Your Ref: OWQC23212
Our Ref: CM/18/19/PL
Please ask for:
Mr Z Denton

29th May 2019

Erection of 2 No 3 bed dwellings with off-road parking and associated landscaping
Land at Entrance to Waterford Gardens Horsemere Green Lane Climping

Thank you for your internet comments made on 28th May 2019 which has been recorded as **'an objection'** with the comments as follows:

drawing title:
Site Plan

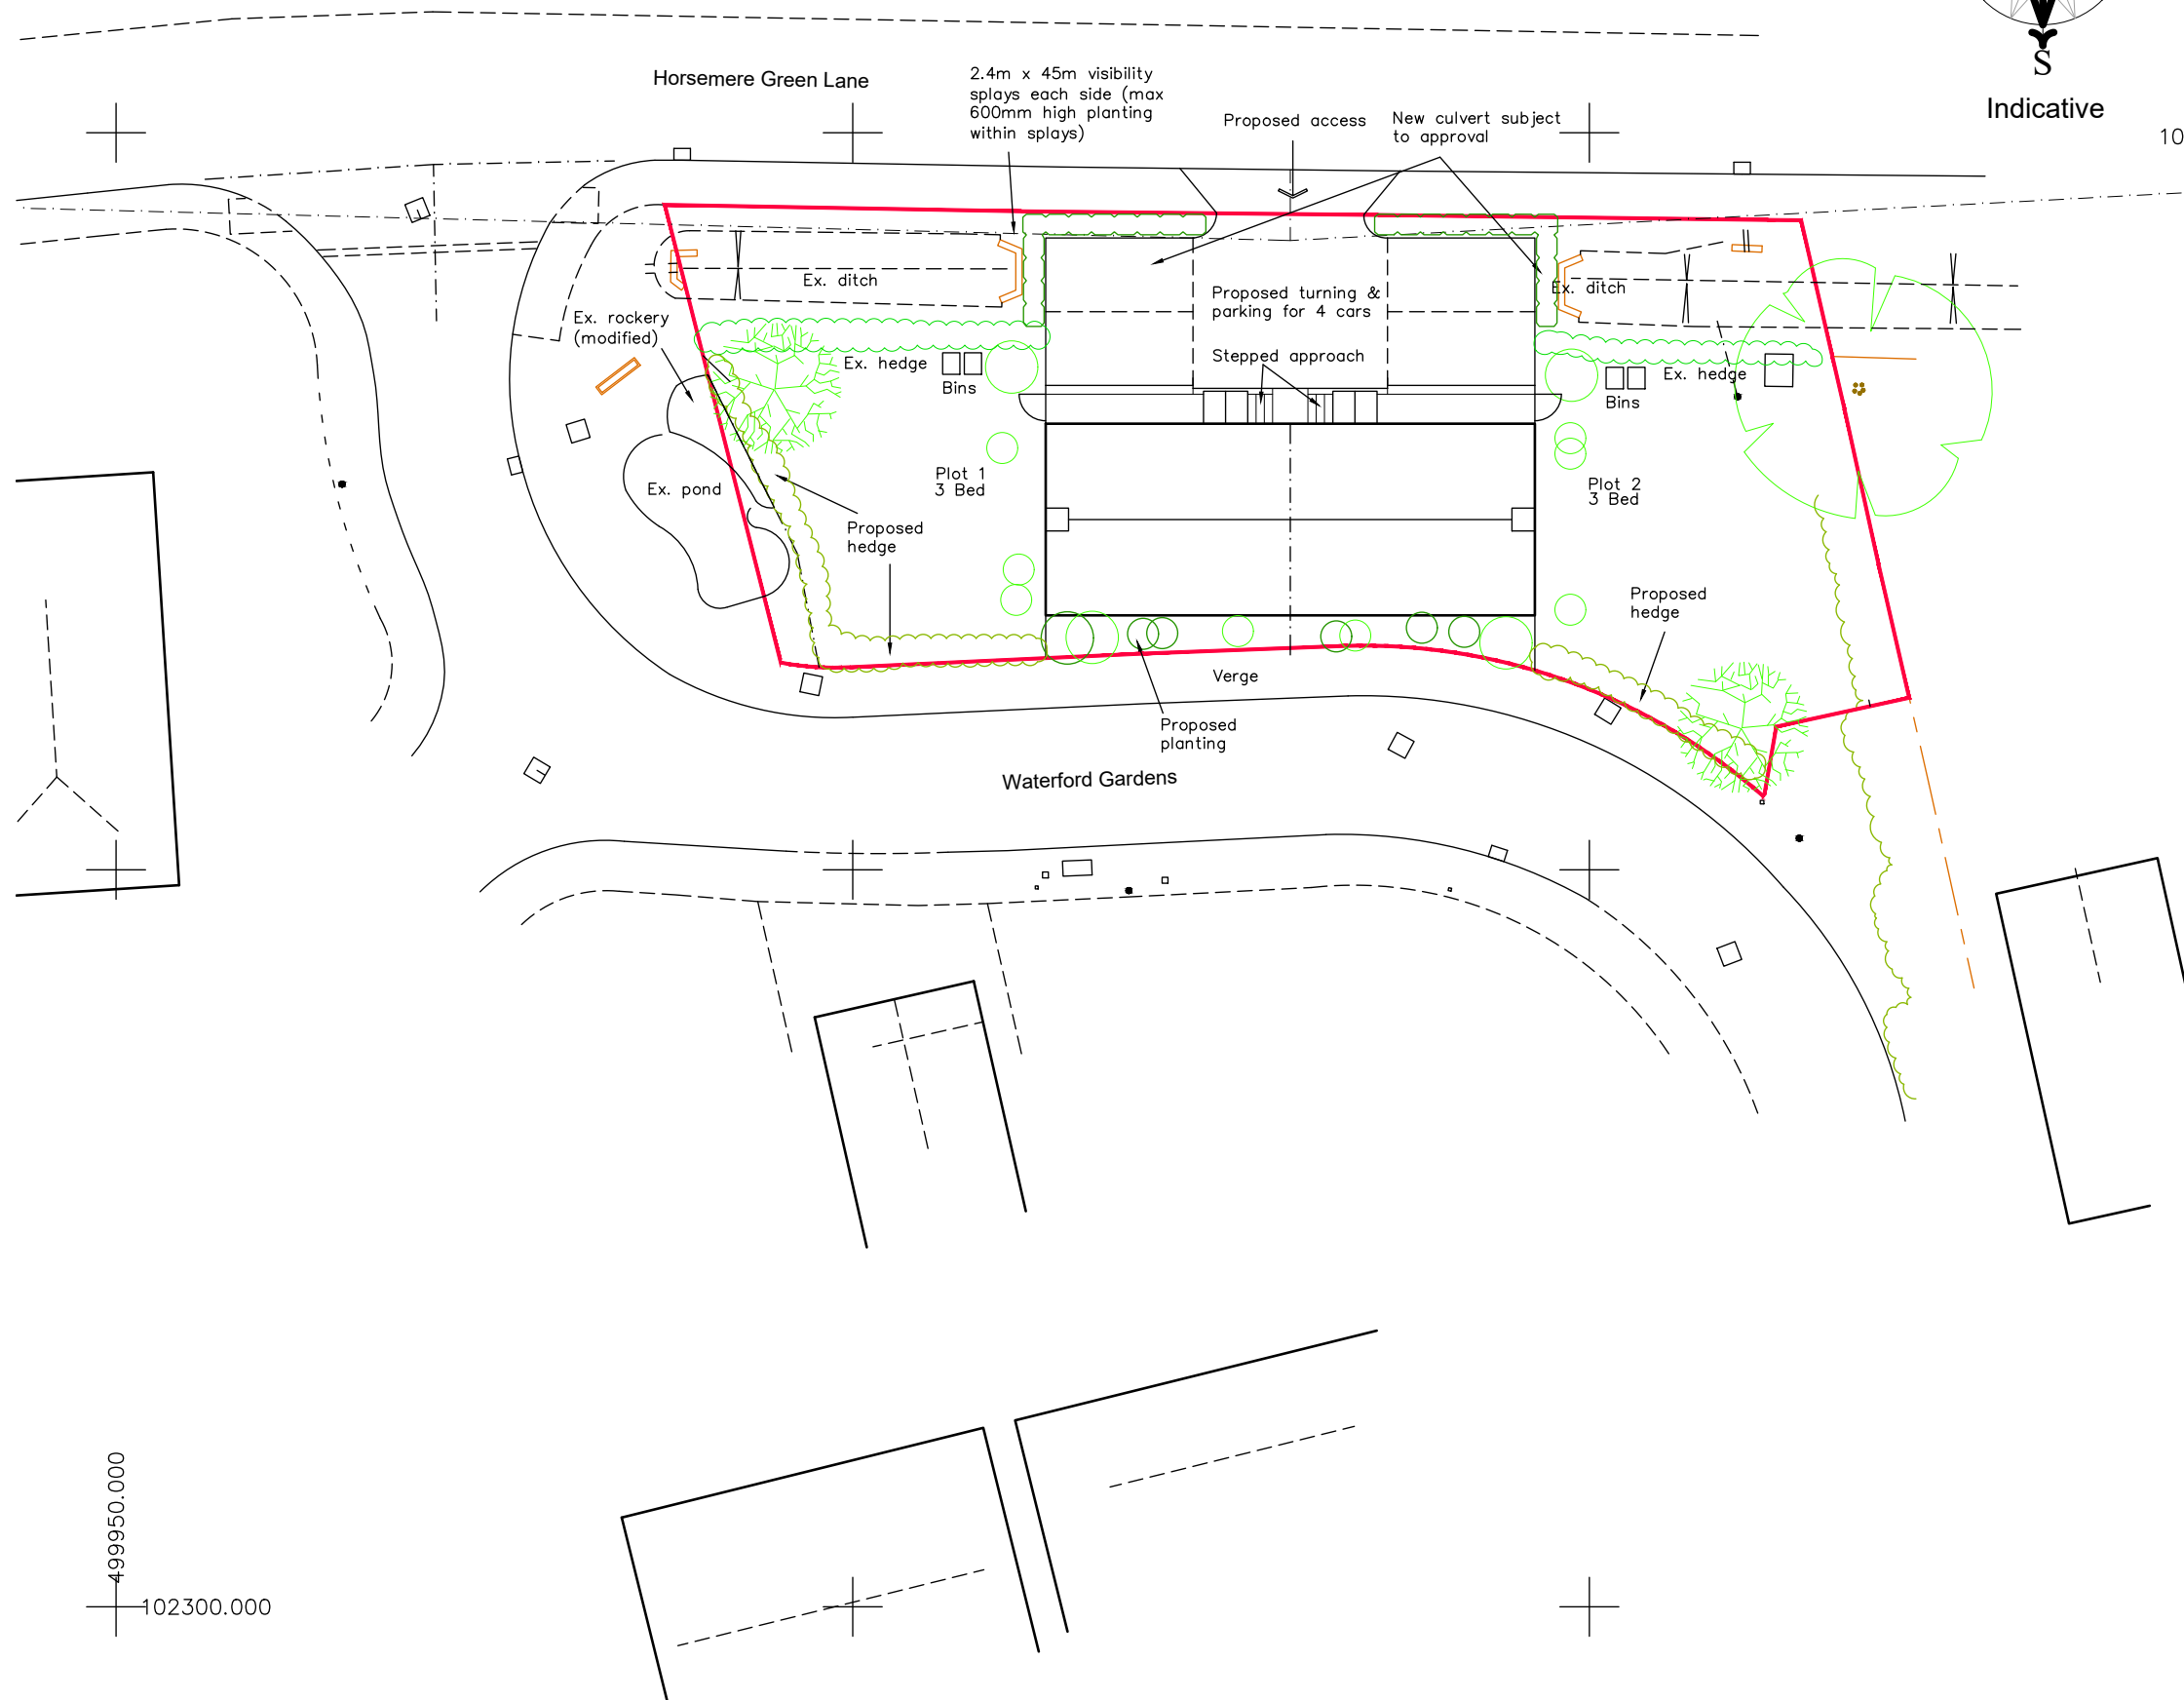
- 1. it is an over-intensive development of the site*
- 2. it would create an additional exit on to Horsemere Green Lane which is not acceptable. There is already an exit road from Waterford Gardens which could be used.*
- 3. it will be out of character and detrimental to the existing street scene. The previous planning permission granted for the site included a condition to preserve the street scene (CM/23/17/PL Condition 10: Notwithstanding the details shown on the submitted plans, the 1.8 metre boundary fence alongside Horsemere Green Lane shall be substituted for a hedgerow, details of which shall be submitted and approved under condition 4 of this Decision Notice. Reason: In the interests of the visual amenities of the locality in accordance with the policy GEN7 of the Arun District Local Plan)*
